APPENDIX C –LETTER RESPONSE TO OEH SUBMISSION
AND FINAL ABORIGINAL HERITAGE ASSESSMENT

RE: Aboriginal Heritage Assessment for the Bomen Solar Farm OEH Issues Response

Please find below our responses to the issues raised by OEH with respect to our recent draft Aboriginal Archaeological and Cultural Heritage Impact Assessment (AACHIA) for the Bomen Solar Farm. For ease of reference, responses to each of the issues raised by OEH are provided below under separate sub-headings.

Figure 22 Areas of Archaeological Sensitivity

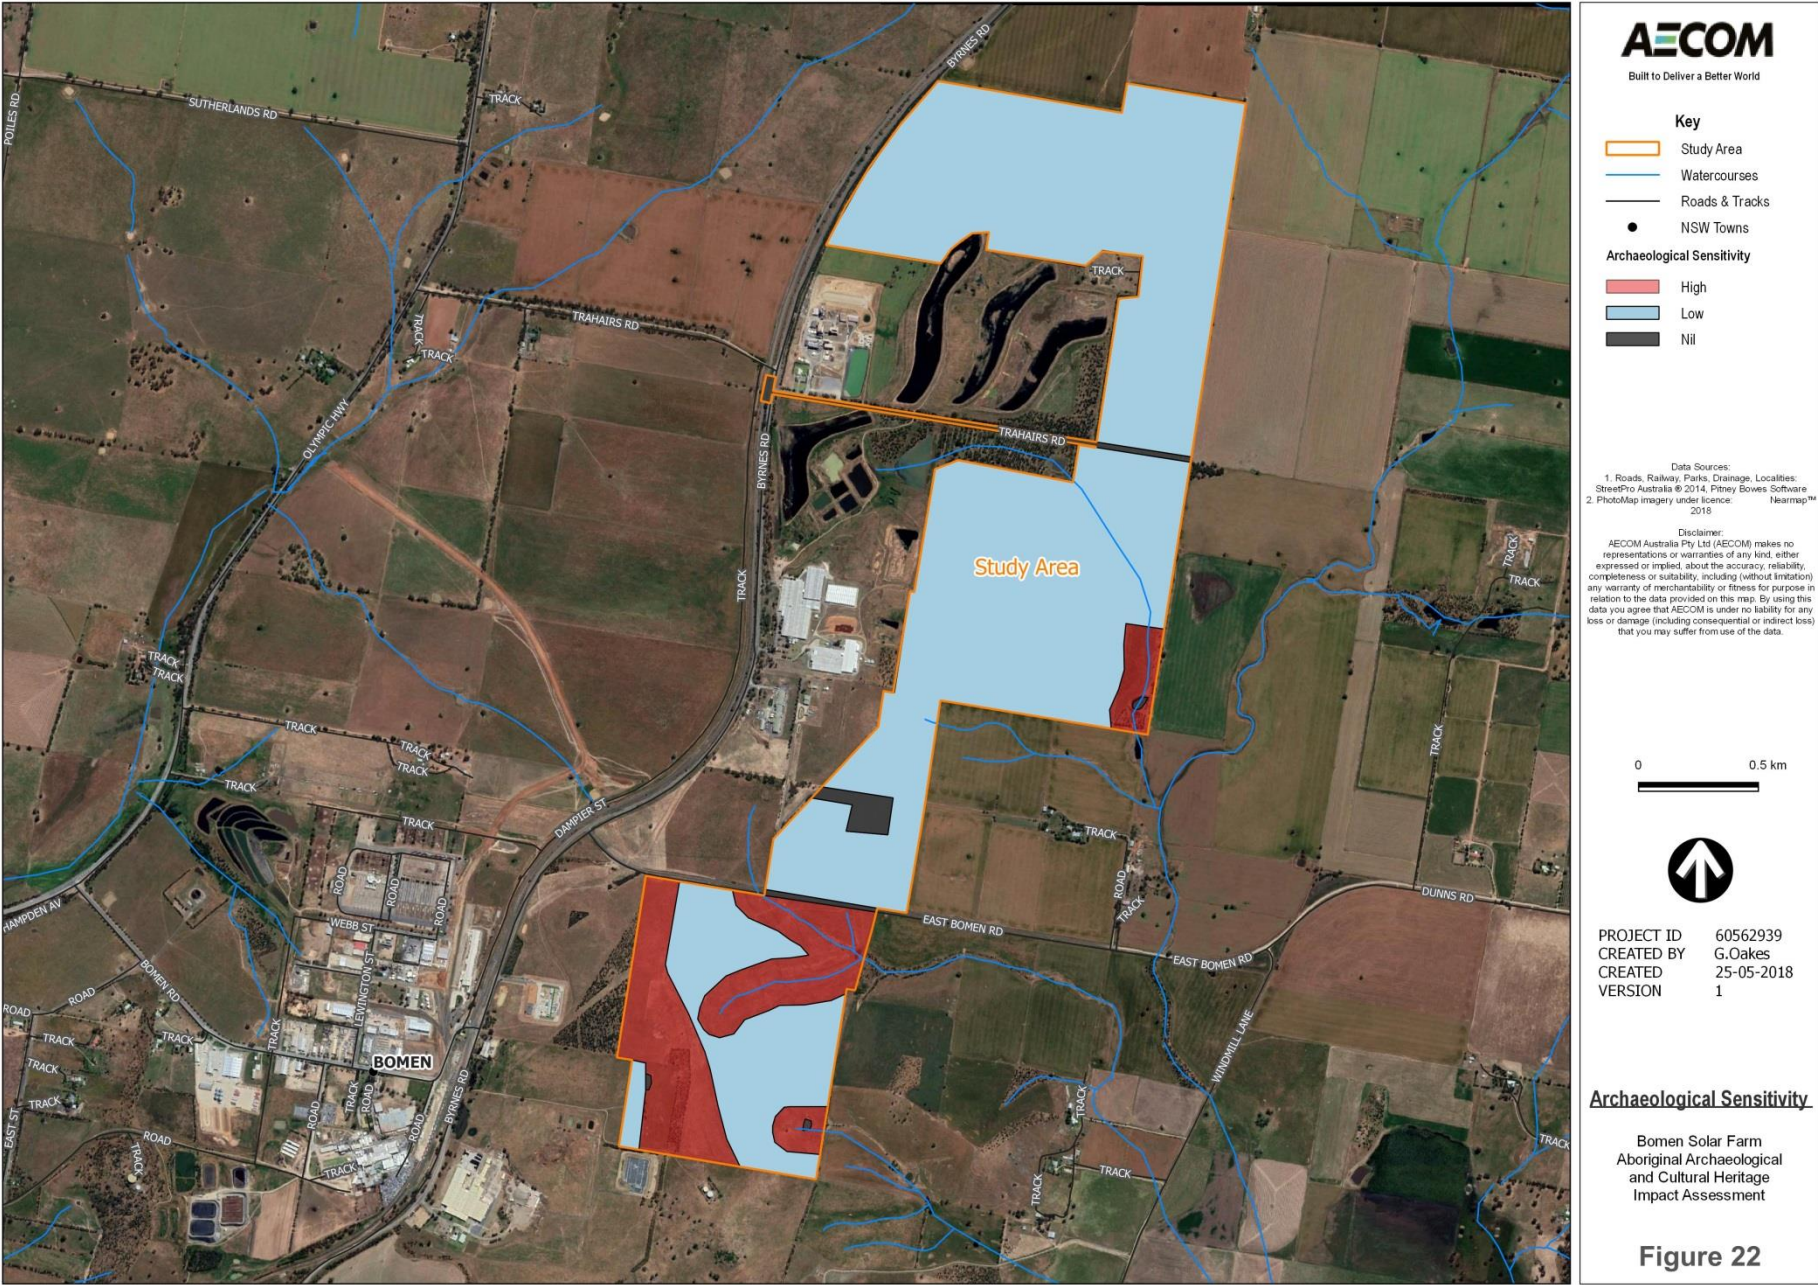
Areas of subsurface archaeological sensitivity have been identified within the southern development area (refer to Figure 22 of the draft AACHIA) and in the area south of East Bomen Road associated with a number of 1st order and small section of a 2nd order watercourse. Areas subsurface archaeological sensitivity within the study area were assessed on the basis of field observations, RAP field comments and existing local and regional archaeological data, as retaining reasonable potential for the presence of subsurface archaeological deposit(s).

The area of subsurface archaeological sensitivity located within the southern development area was associated with a 1st order drainage channel. An archaeological test excavation program was subsequently undertaken in this area to determine the nature and extent of subsurface archaeological materials in that area. The overall pattern of subsurface artefact distribution demonstrated by the testing suggested limited Aboriginal use of the low gradient landform elements adjacent to the 1st order creekline subject to testing. Observed artefact densities (range: 0 to 5 artefacts per 0.25m²) were consistent with the presence of a low density "background scatter" of material resulting from limited episodes of lithic discard. As such, the associated site was assessed as of low scientific significance.

Areas of subsurface archaeological sensitivity were also identified with the proposed transmission line corridor options located to the south of East Bomen Road, comprising low gradient landform elements adjacent to sections of three 1st order ephemeral drainage lines and a small portion of a 2nd order creekline. These areas were not subject to archaeological test excavation during the assessment field program as the final transmission line route option has not yet been determined. As archaeological test excavation is a destructive process, whereby the original context of a find is destroyed in order to make observations, undertaking these works prior to the selection of the transmission line route was considered inappropriate. Test excavation, and potential salvage excavation within these areas has been recommended in the AACHIA and will be undertaken once the route has been finalised. The route cannot be finalised until the detailed design phase of the project.

Figure 25 Impact Assessment

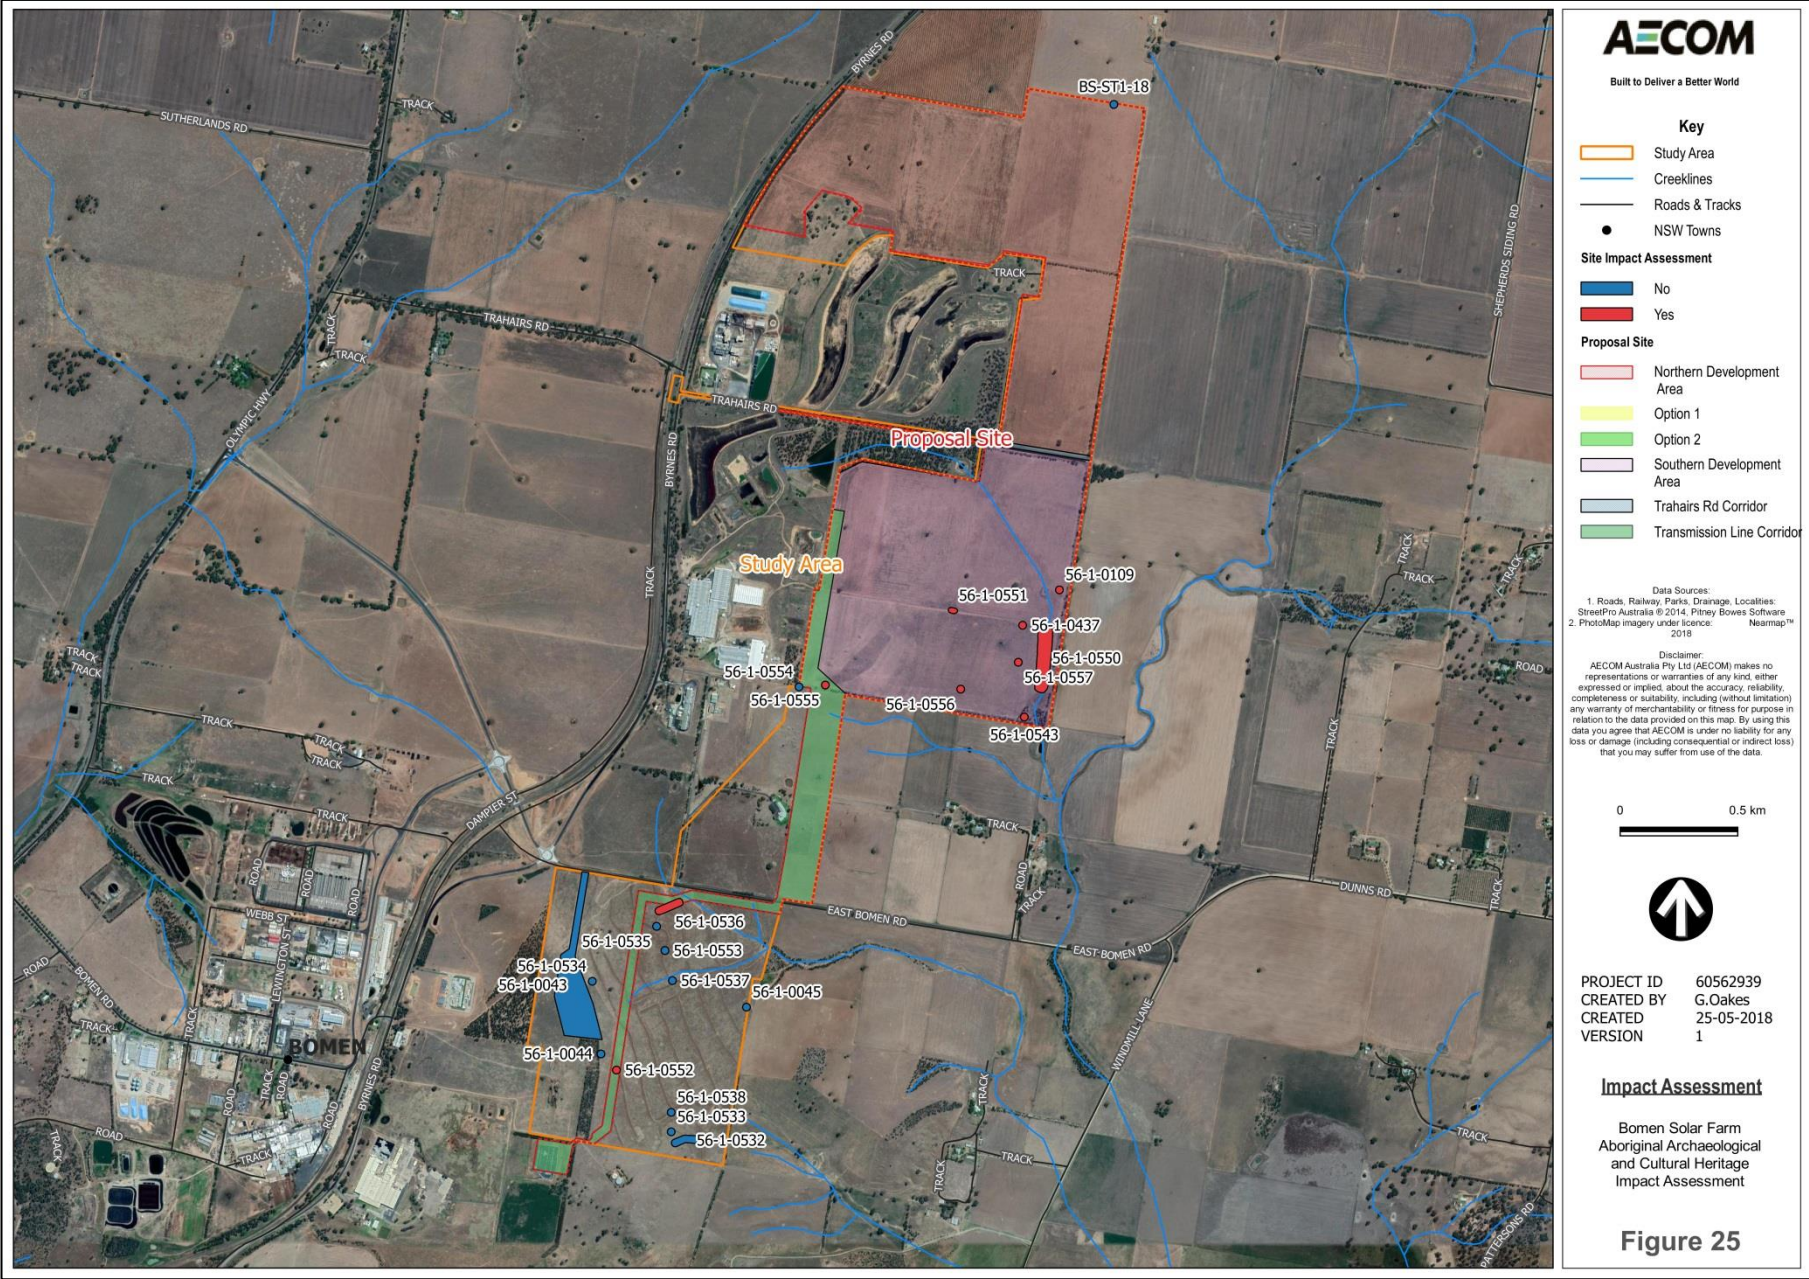
Issue 9: To make it clear to the reader, a map should be prepared to indicate Aboriginal sites that are proposed to be harmed by the development and sites that will not be harmed by the proposal. The map could be linked to a table (e.g. Table 35). Zoomed in maps may be necessary to shown sites near the boundaries of the project area.

Updated
